This is to certify that 142 Presumpscot Limited/sel
 has permission to Amendment to permit # 0408 / Install metal joists mezzanine for storage.
 AT 142 Presumpscot St 425 1004001

City of Portland, Maine - Building or Use Permit Application

Proposed Use: Amendment to permit # 040866 / Install metal joist to mezzanine for storage.	Proposed Project Description: Amendment to permit # 040866 / Install metal joist to mezzanine for storage.
--	--

142 Pennington St
 RAILINGS
 YGSI Y

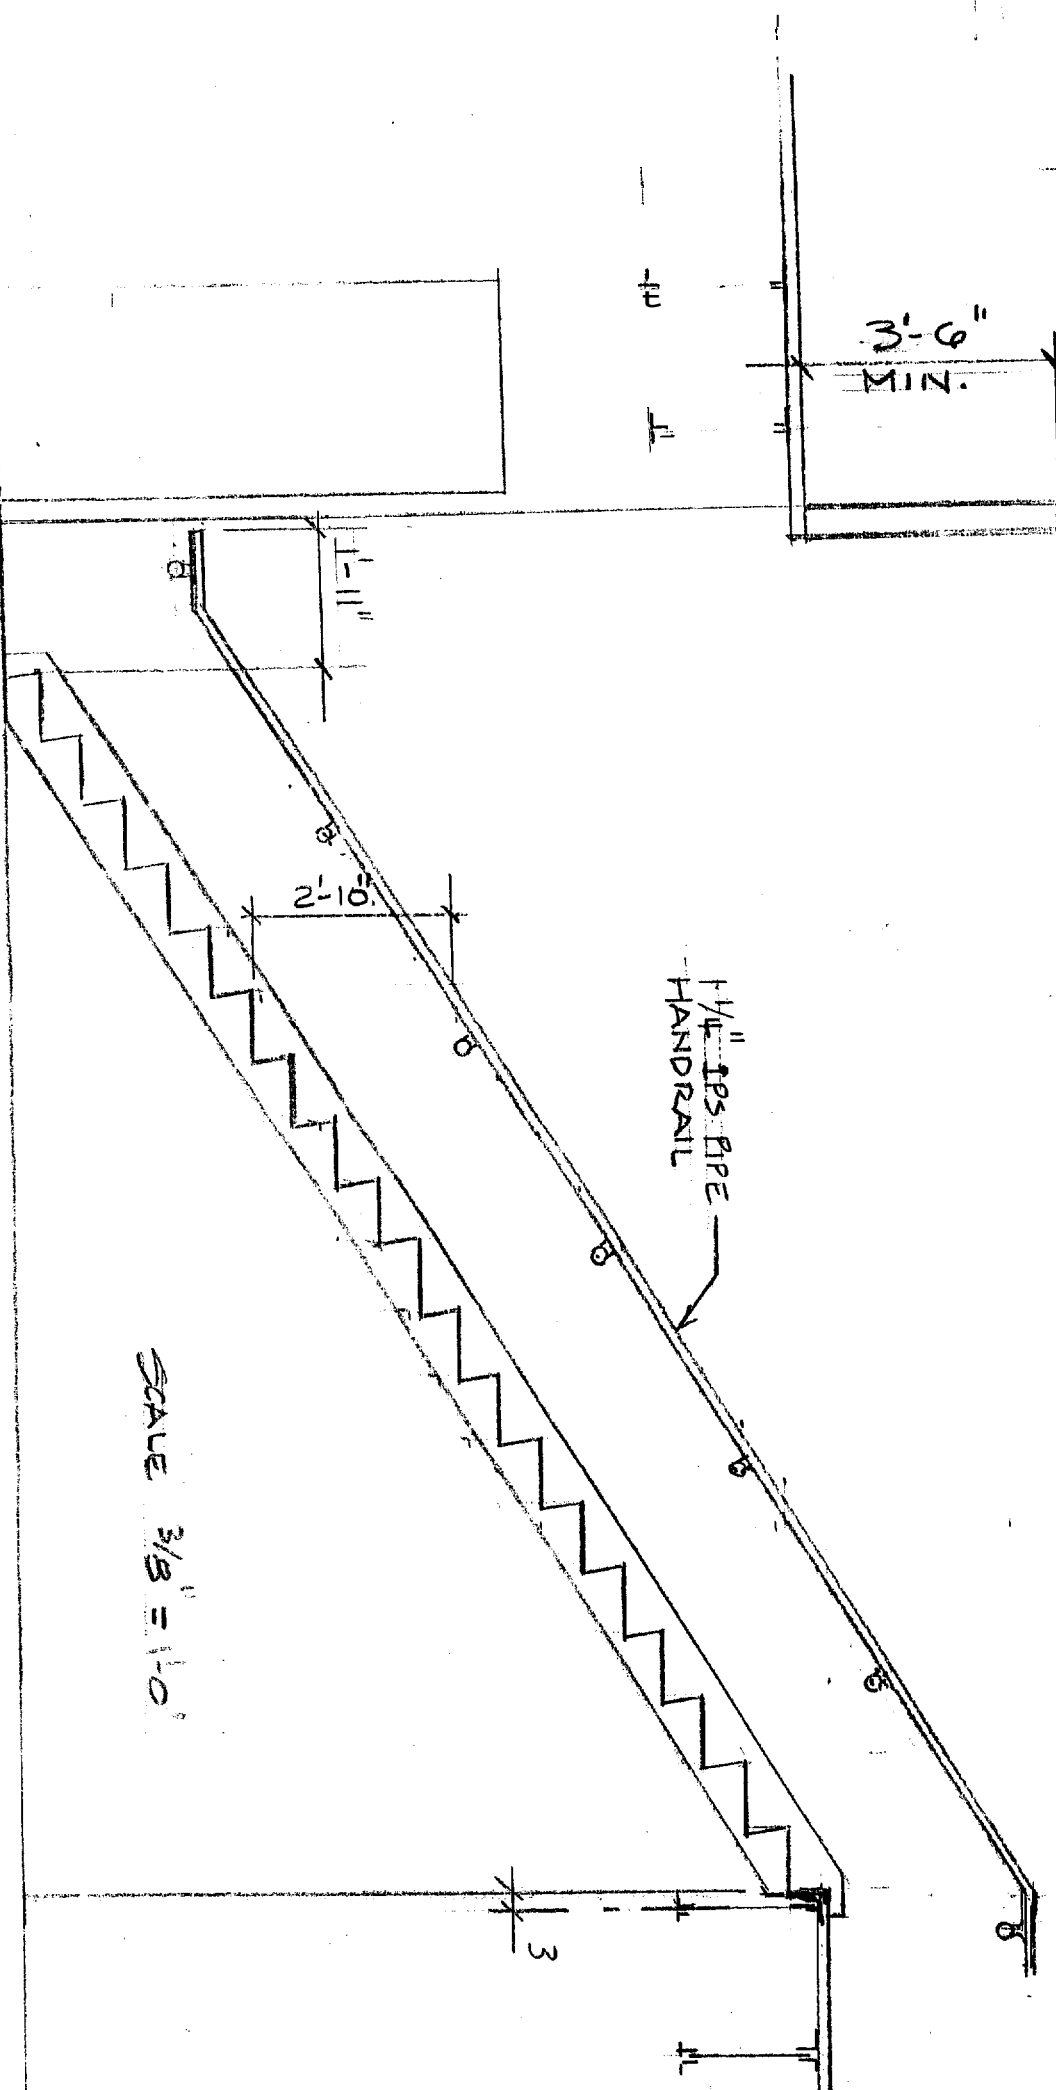
Need: laoding/use/complete stair detail/Guards/Openness/The framing details appear to be incomplete

MEZZANINE FRAMING PLAN & SECTIONS

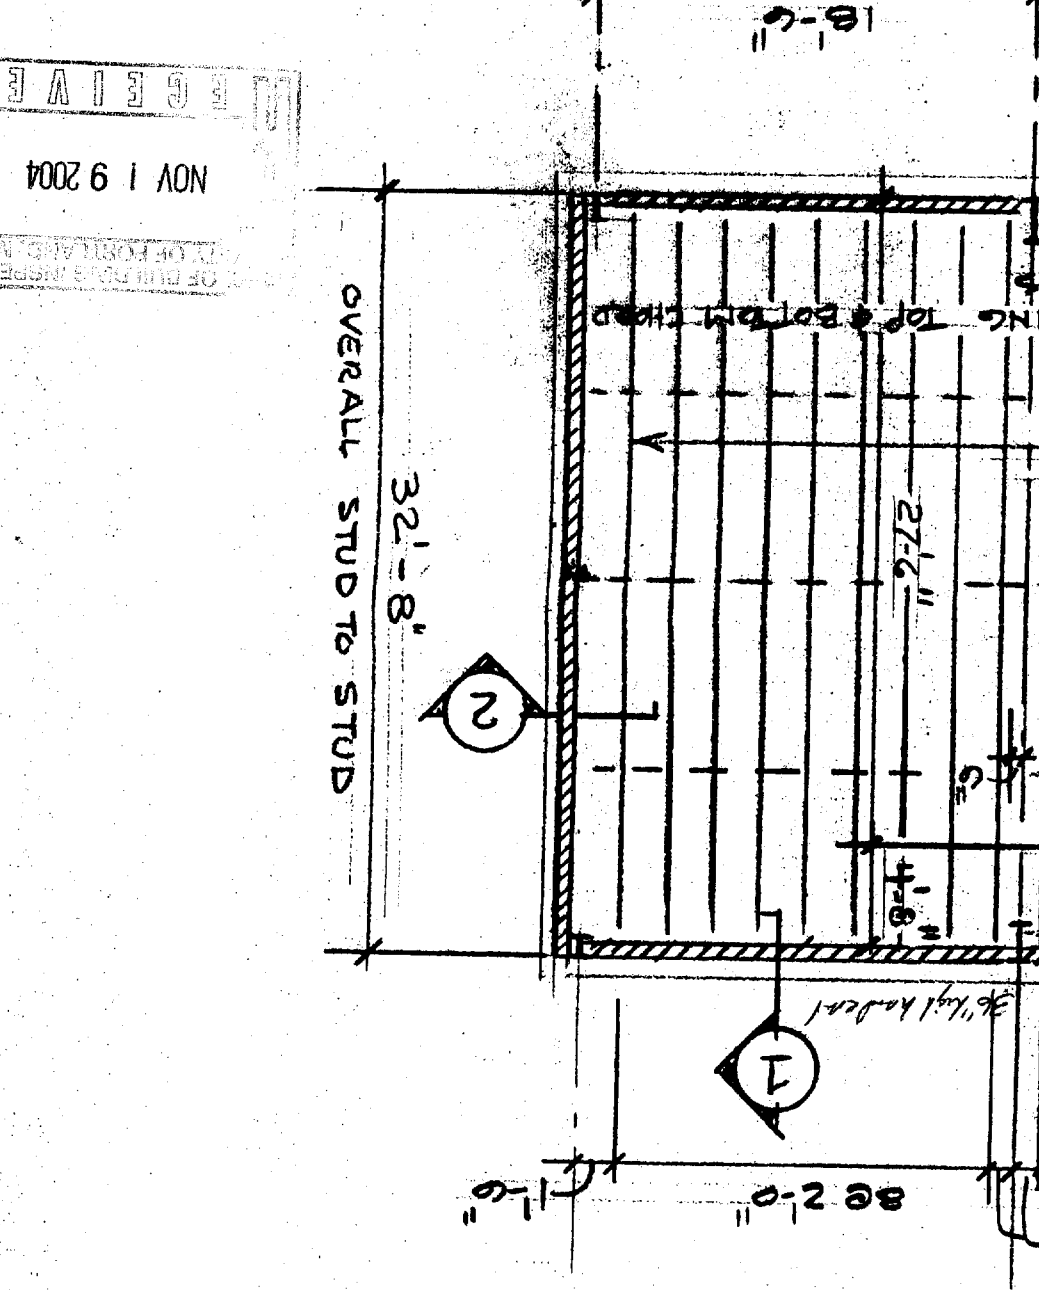
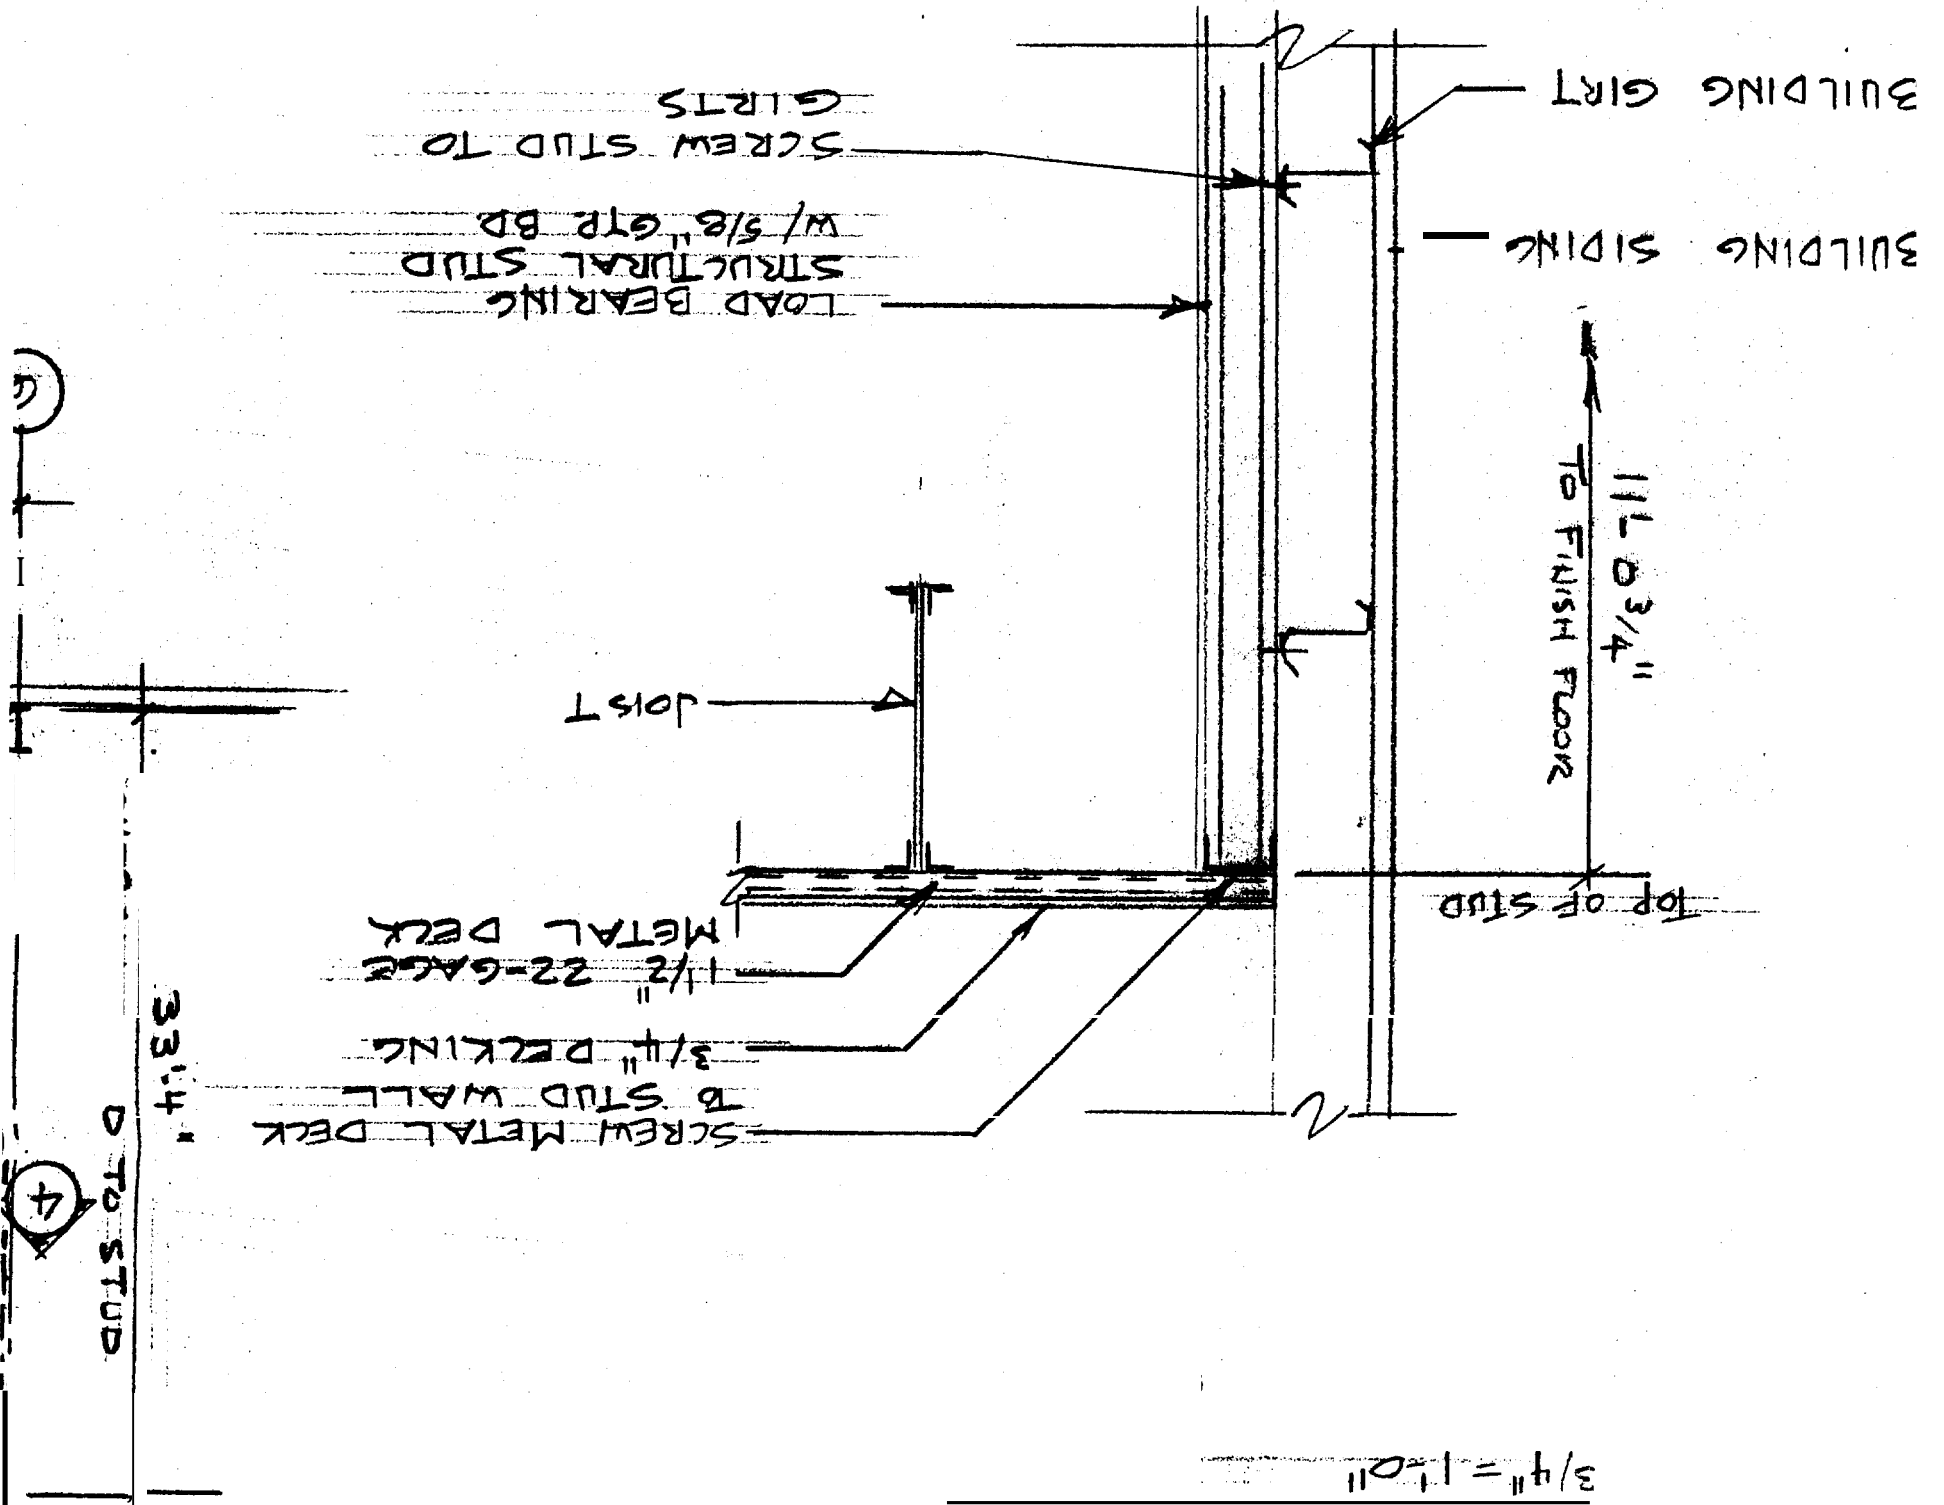
12/14/2004-mjn: Plans insufficient, owner and engineer notified.....

1) Complete special inspection program required for steel, owner advises that the same engineer will be providing that service.
